December 19th, 2023

Planning Application No. 3/2023/0881
Grid Ref: 373799 441149
Location: 4 Reeford Grove, Clitheroe. BB7 1DA

This letter is in regards to the planning application no.3/2023/0881.

Client:	Mr & Mrs Sharples		
Project:	Proposed Gateway Alterations 4 Reeford Grove Clitheroe		
Drawn By:	Proposed Plan & Elevation		
Scale 1:50	1:50	Date 07.11.23	Drawn By PD
Drawing No.	1530 - 02		Rev: -

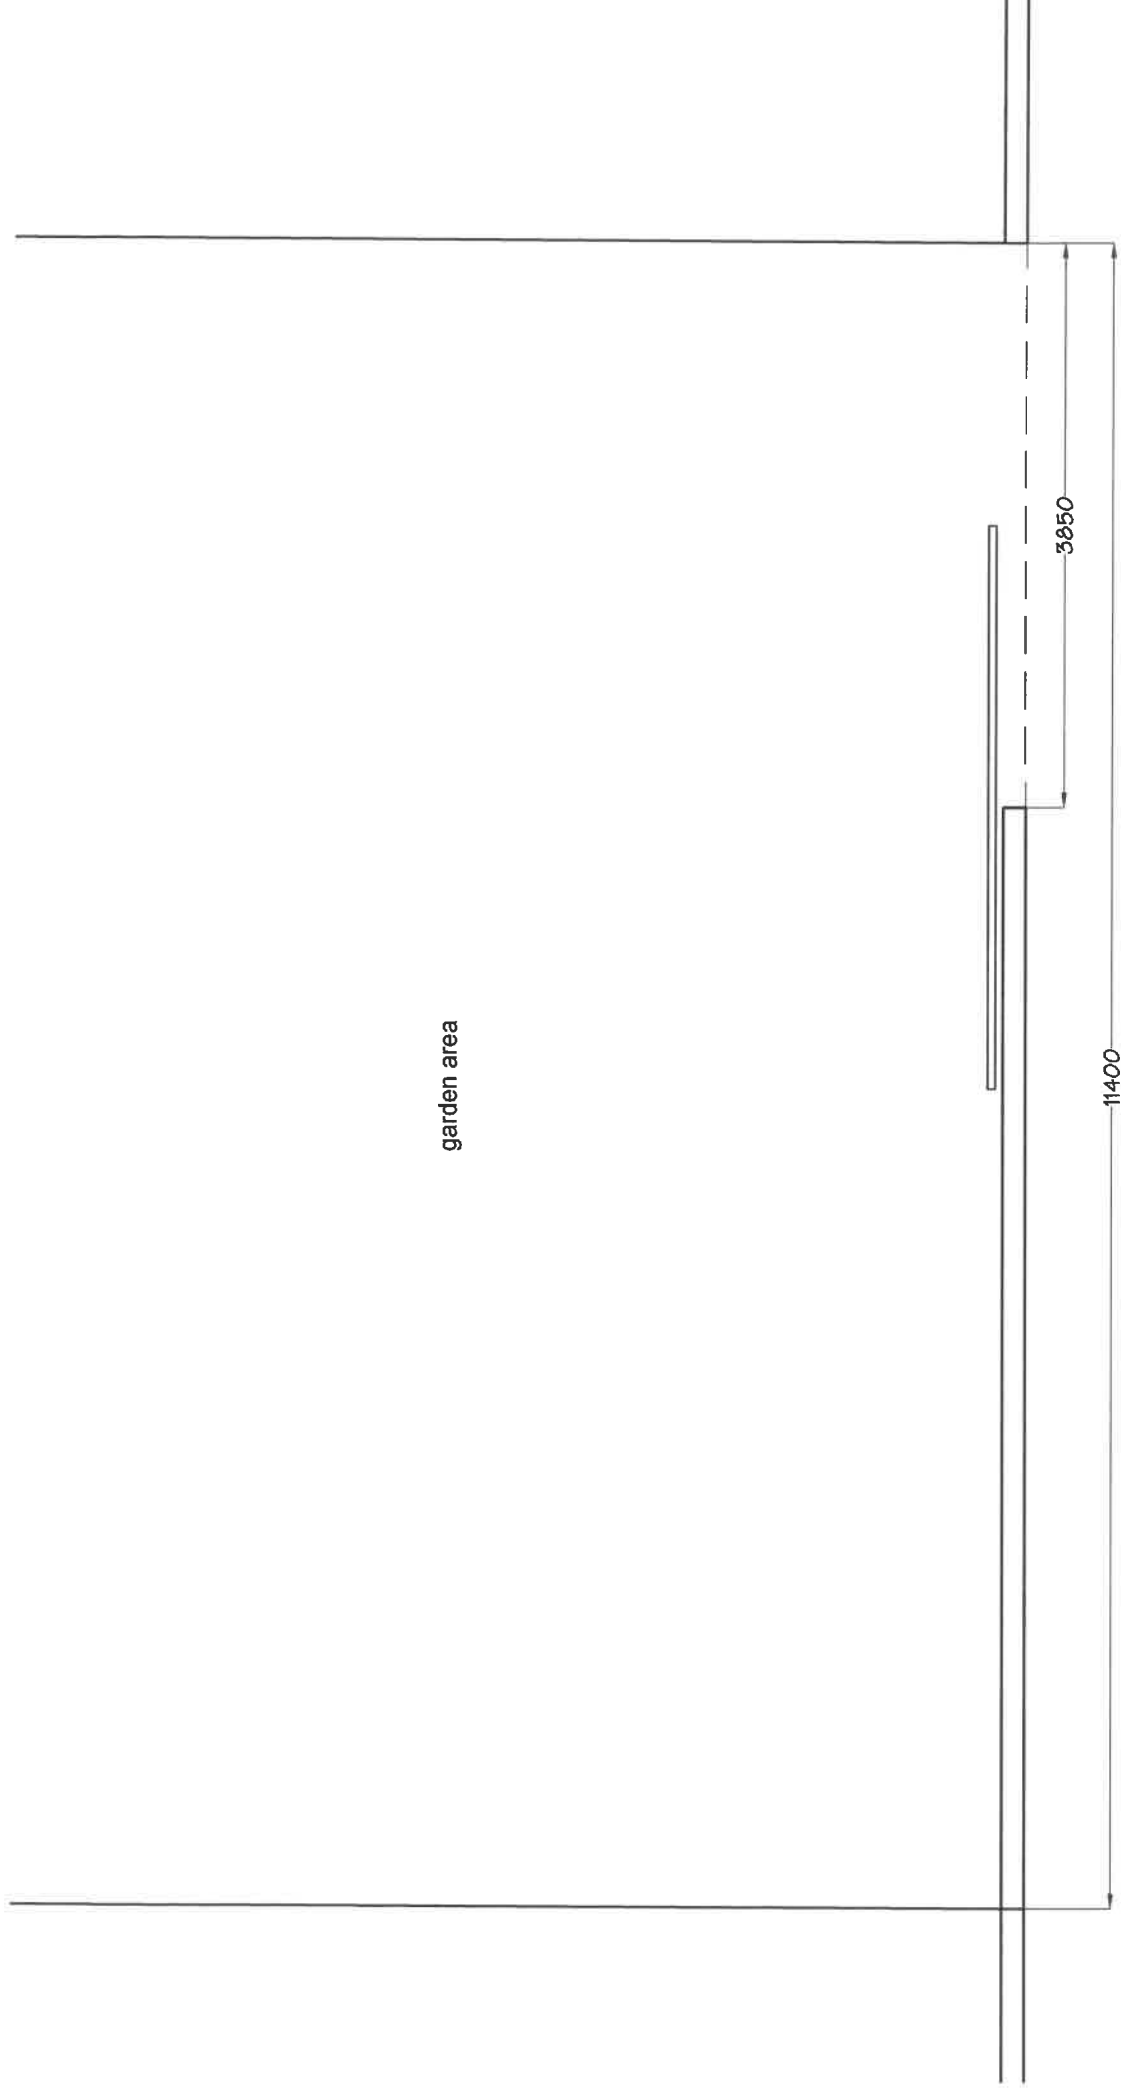
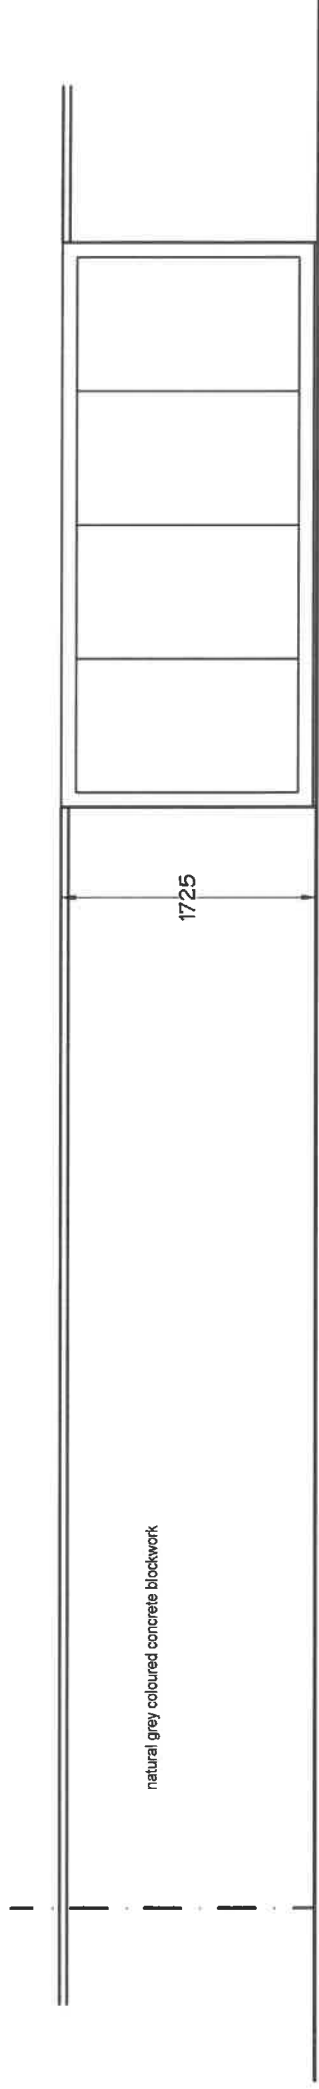
1. It is a retrospective application and not proposed as the applicant has submitted.
2. The plans and measurements are incorrect and misleading. The gated entrance is far larger than indicated and is proportionally larger to the remaining wall than illustrated on plans.

4. At nearly 5 metres in width (the width of two vehicles) and being electric, it is evident by the applicants submitted statement, and his original comments in 2022 as to its intended use for off street parking. This use will cause further disruption, anger and objections as well as road safety issues and air/noise and light pollution/ nuisance for all surrounding residents.
